Application Reference: 6/2022/2065/COND

Proposed development at: Hertfordshire Constabulary Stanborough Road Welwyn Garden City Hertfordshire AL8 6XF

Proposal: Submission of details pursuant to conditions 1 (Gosling Sports Park car park), 9 (phase 1 car parking disabled access), 13 (c only) (tree protection), 17 (phase 2 - car parking disabled access), and 20 (phase 3 non-native species management) on planning application 6/2021/2125/MAJ

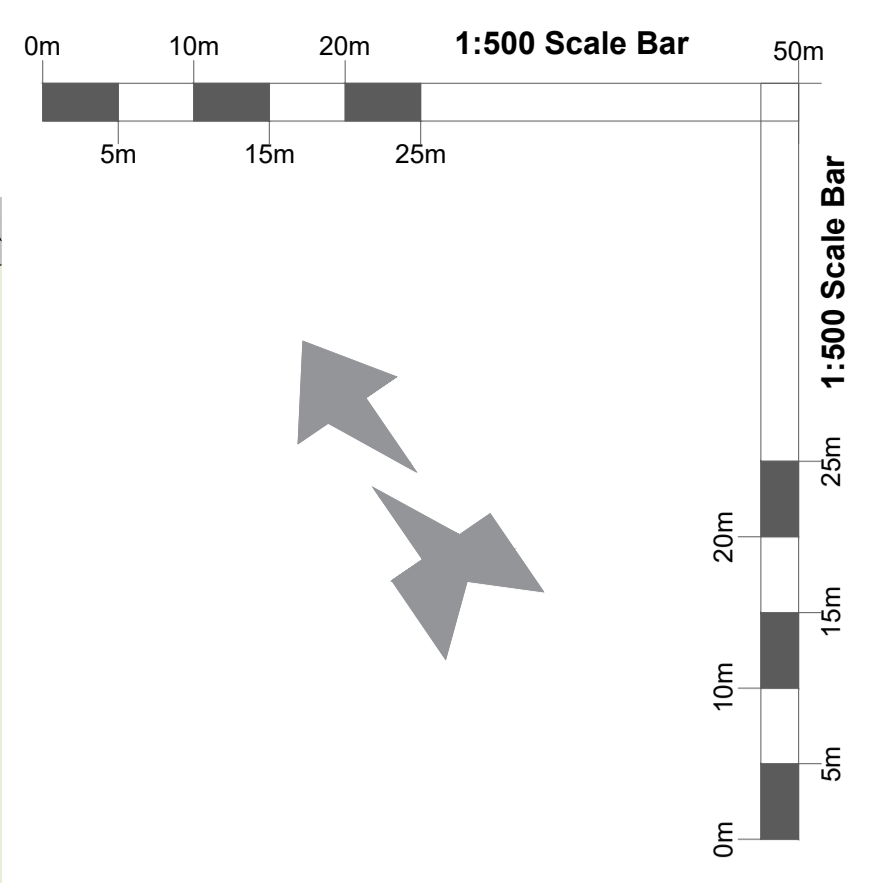
A car survey was submitted on the 2/11/2022 by the agent. This shows that there were sufficient car parking spaces maintained during the car survey period. However, concerns are raised that the total number of car parking spaces for the site is not in accordance with the total number of car parking spaces within the planning history for Gosling Sports Centre. This is exacerbated by the annotation on drawing number HCHQ-VGA-XX-XX-DR-AR-00140-PL01 received 5/9/2022 which says 'approximate').

There are also inaccuracies in the total number of car parking spaces to be removed from use which varies from 74 to 80. There are concerns that these factors may distort the conclusion of the car parking survey.

Also, significant concerns are raised that the loss of 74 car parking spaces within the Gosling Sports Centre is not being used as contractor and operatives parking. This is in conflict with planning references 6/2021/2125/MAJ and 6/2022/2284/COND which have support from Hertfordshire County Council Highways Team based on contractor and operatives parking being within the Gosling Sports Centre.

Please update the car parking survey accordingly.

### Proposed Site Plan Decant accessible parking route to entrance Condition 9

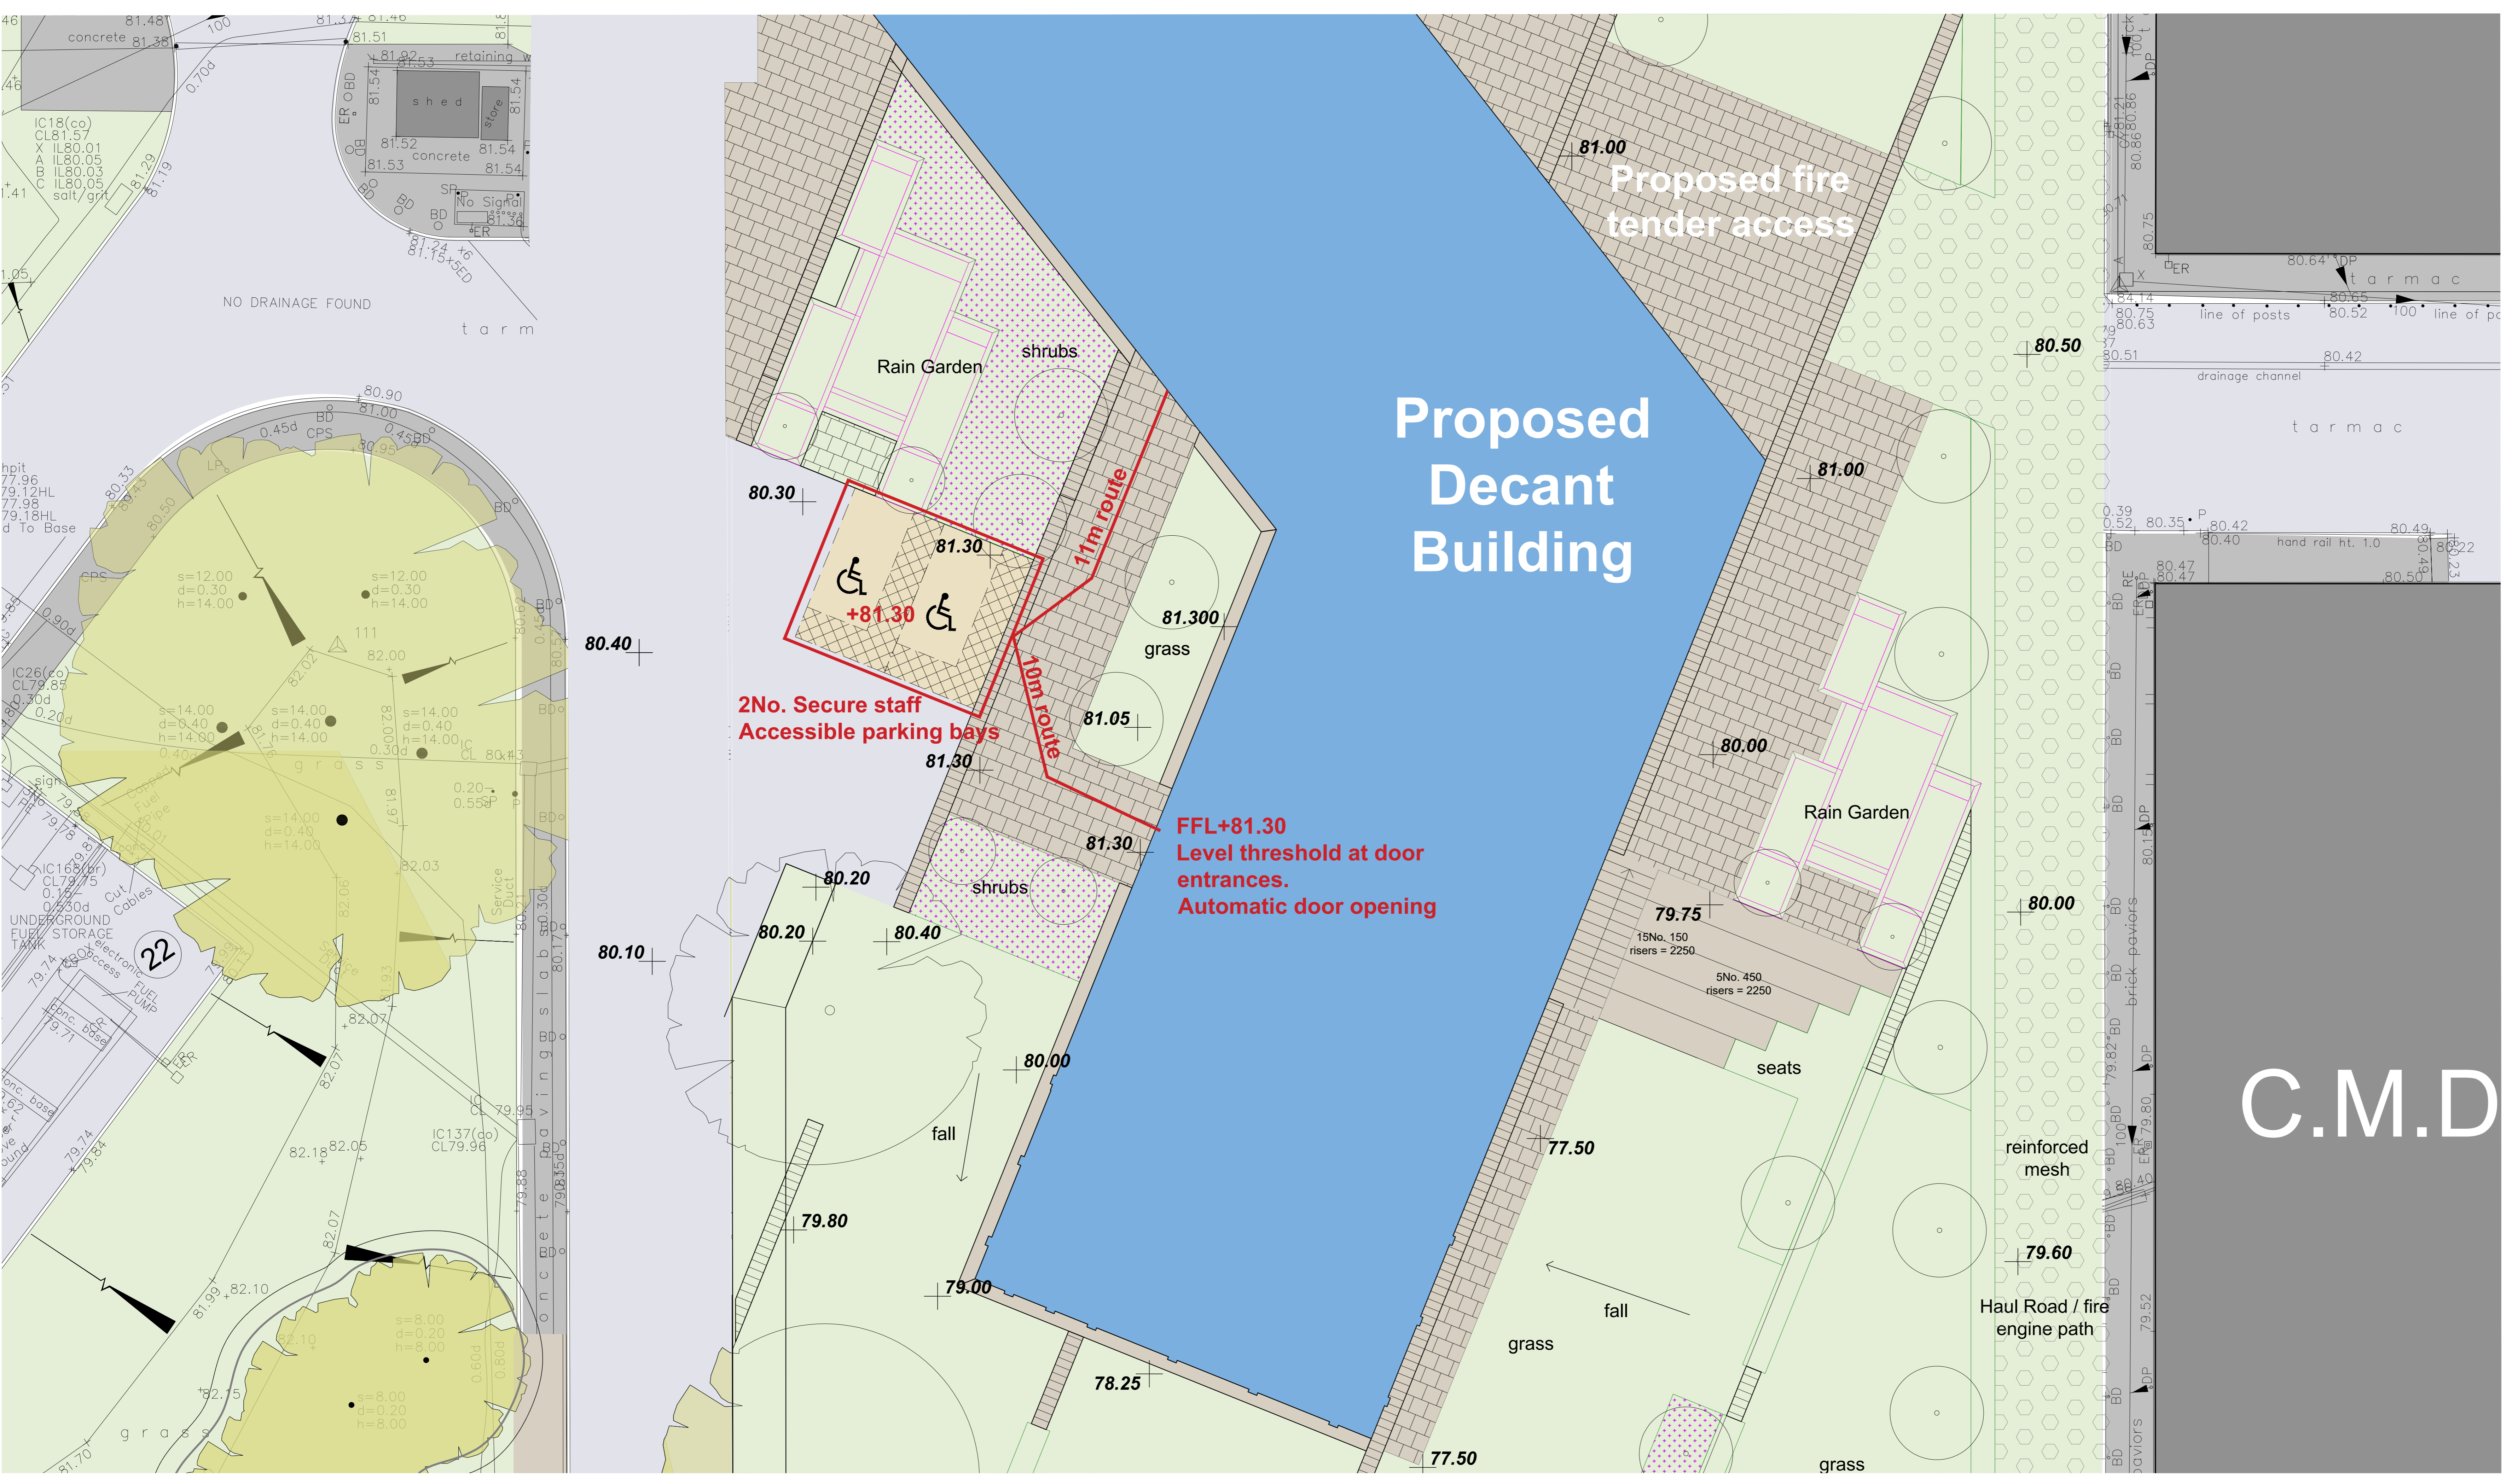
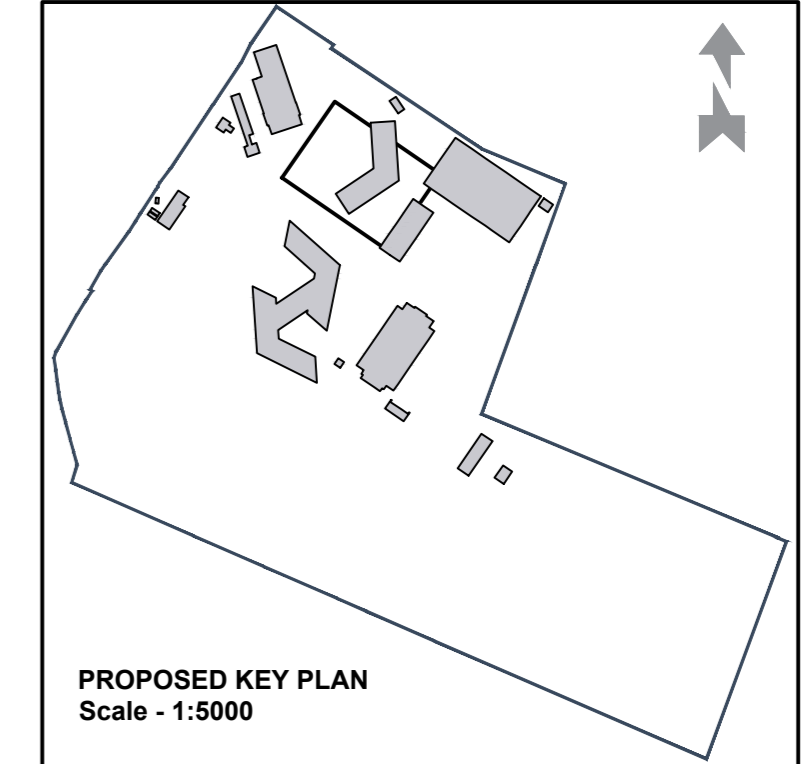
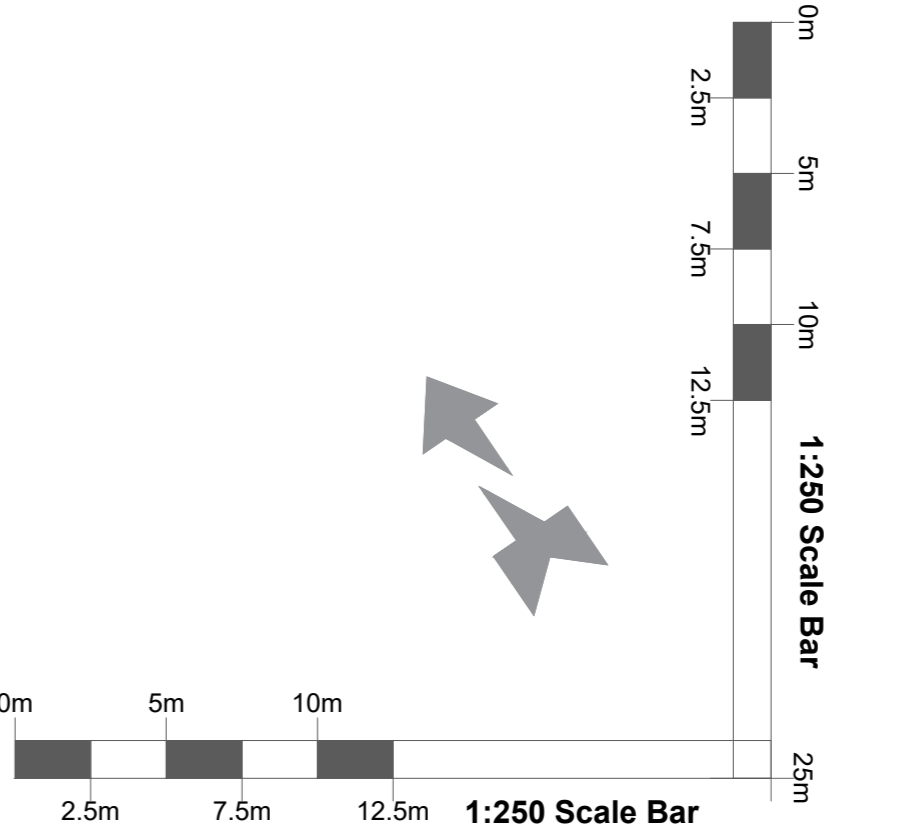
On comparison of the above plans and the explanation within the delegated report and the wording of the condition, it is not considered that the wording of the condition has been met.

Proposed Site Plan HQ Accessible parking route to entrance Condition 17

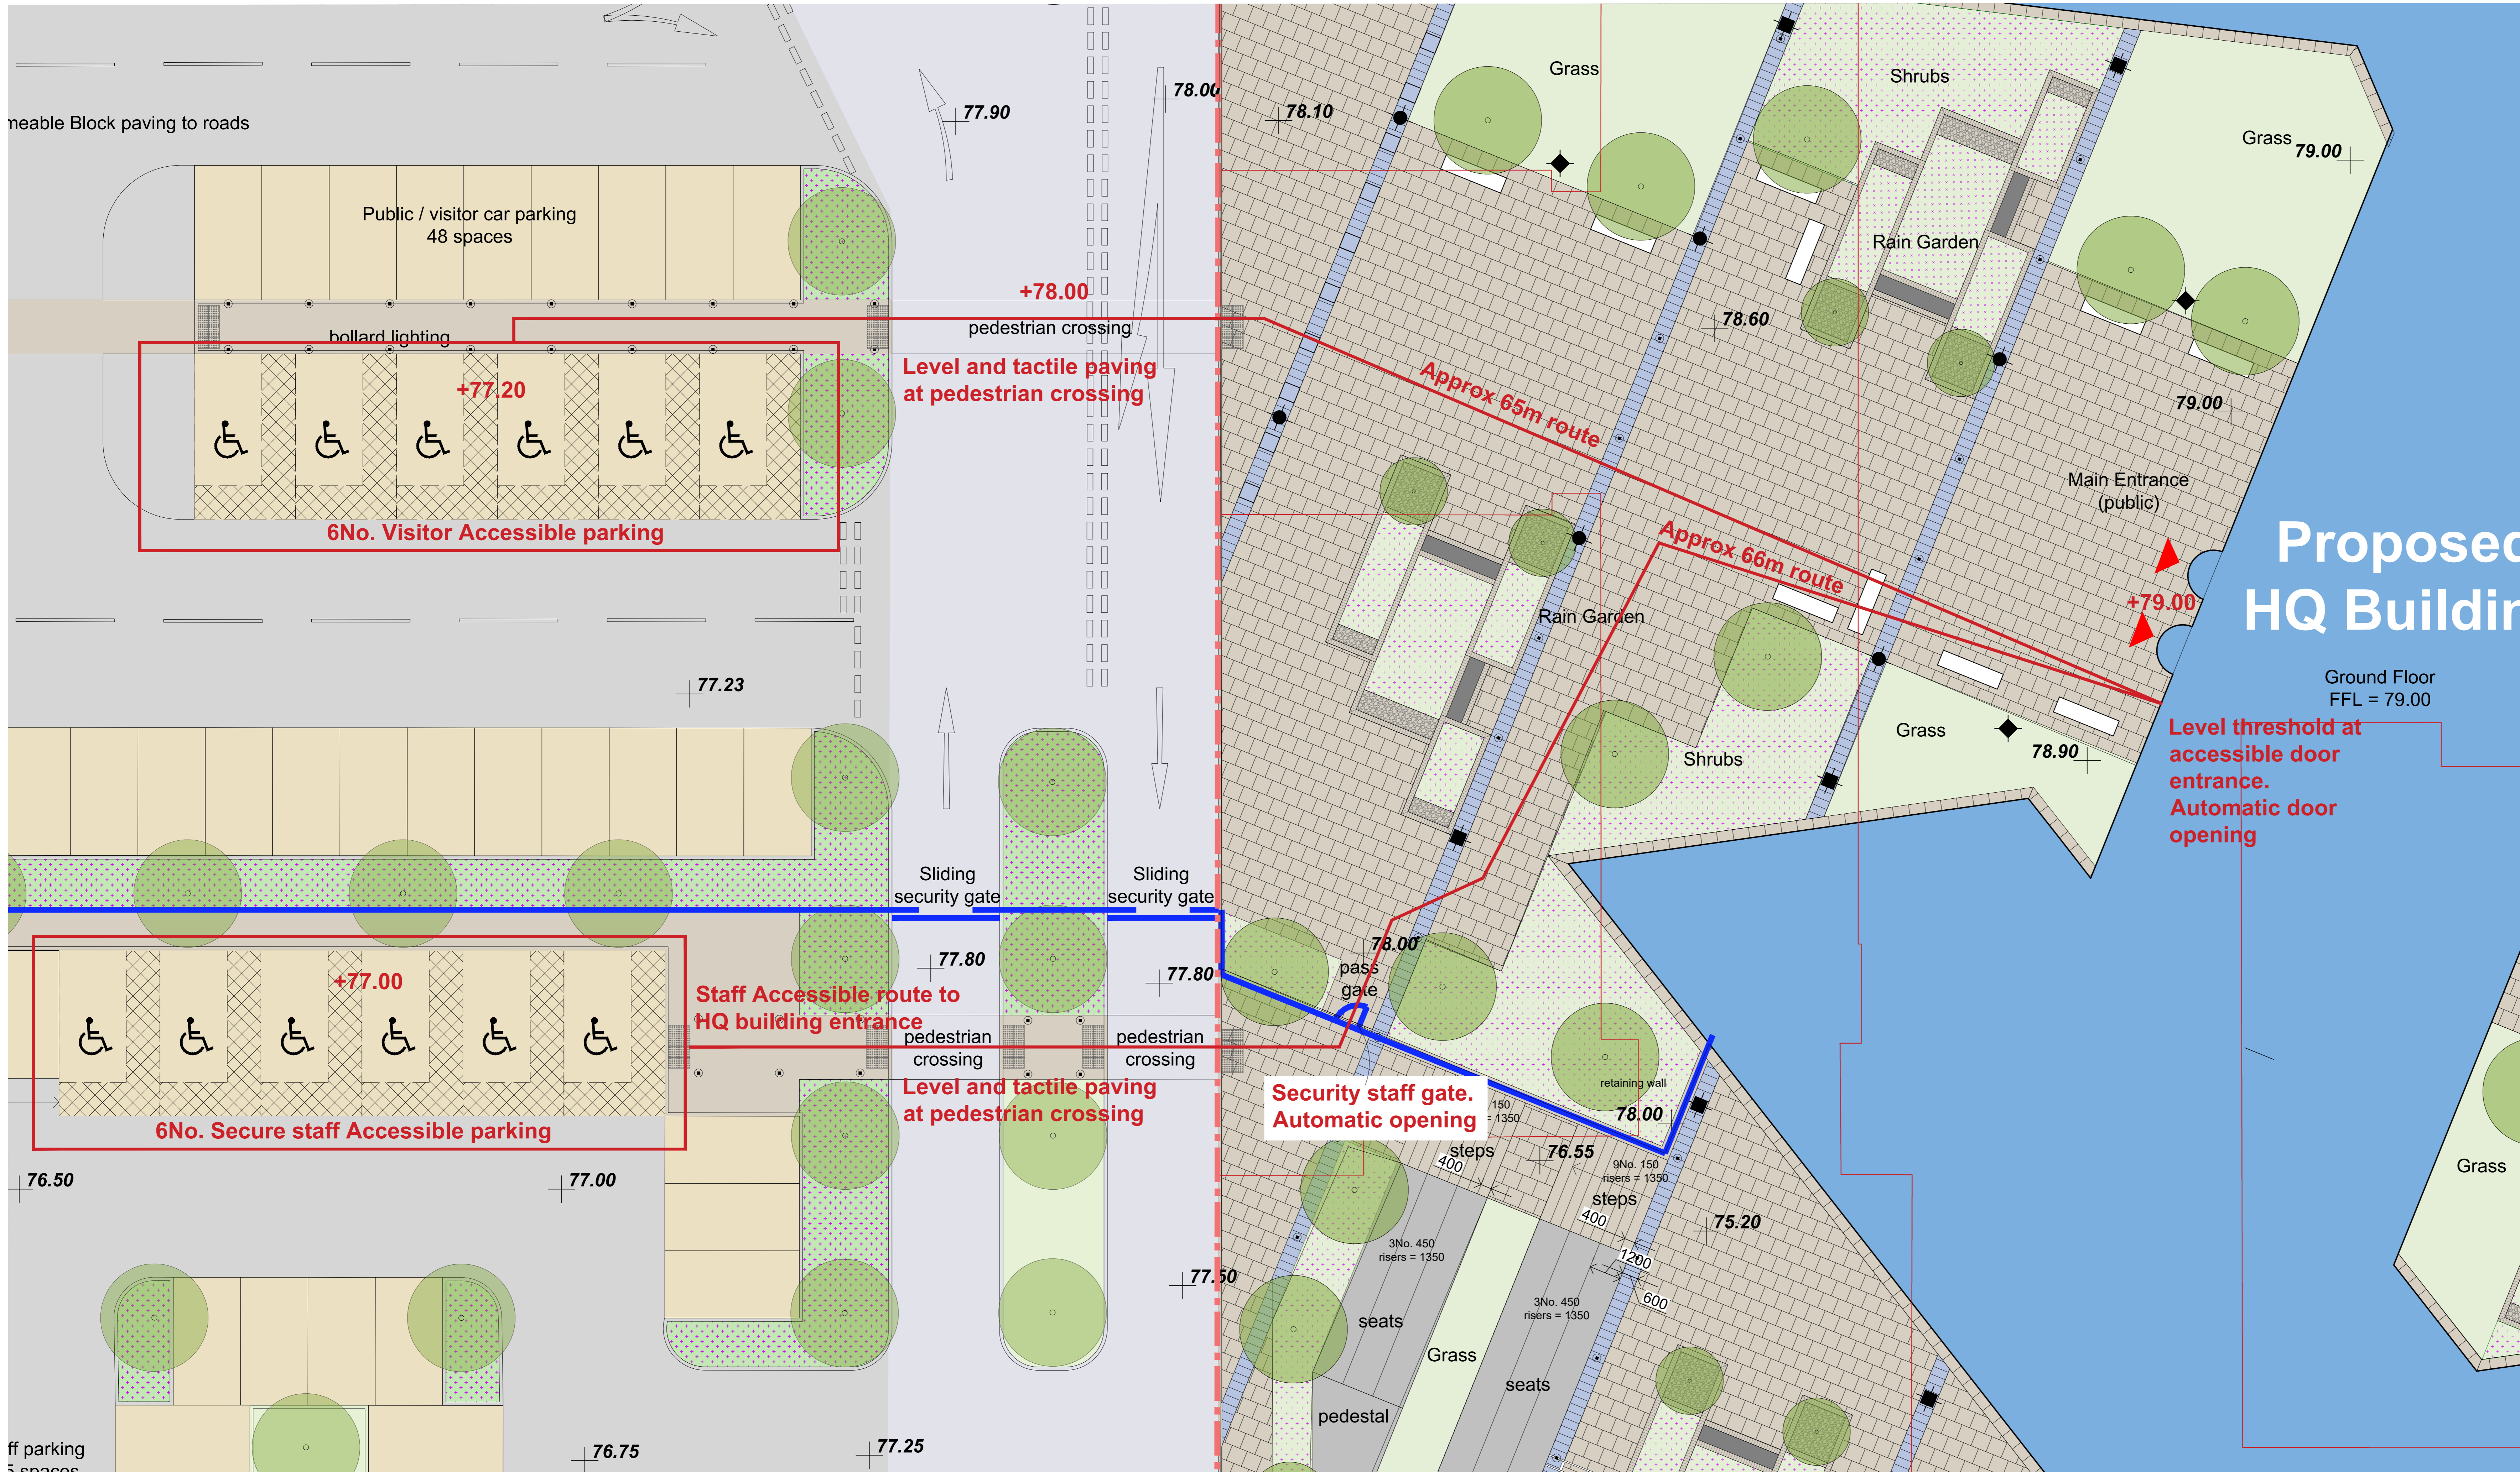
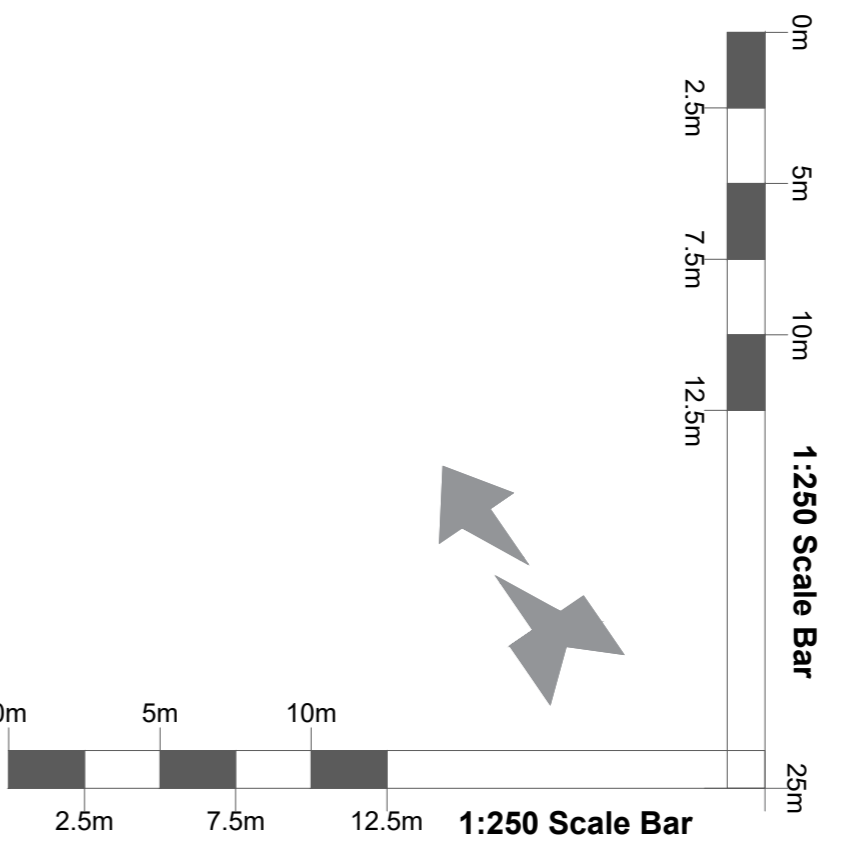
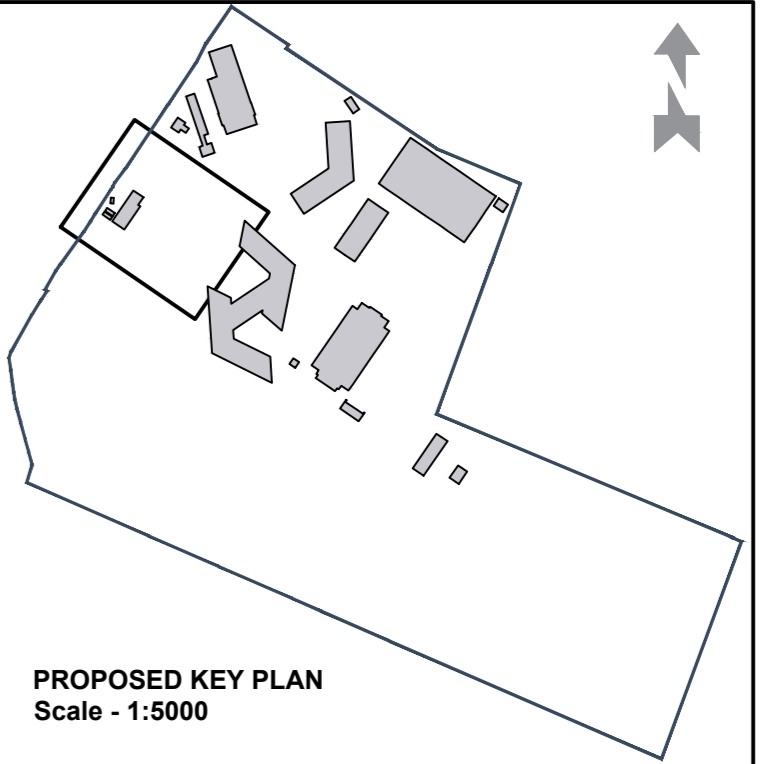
- Drawing number HCHQ-VGA-XX-XX-DR-AR-00144-PL01 received 5/9/2022. On comparison of the above plan and the explanation within the delegated report and the wording of the condition, it is not considered that the wording of the condition has been met.
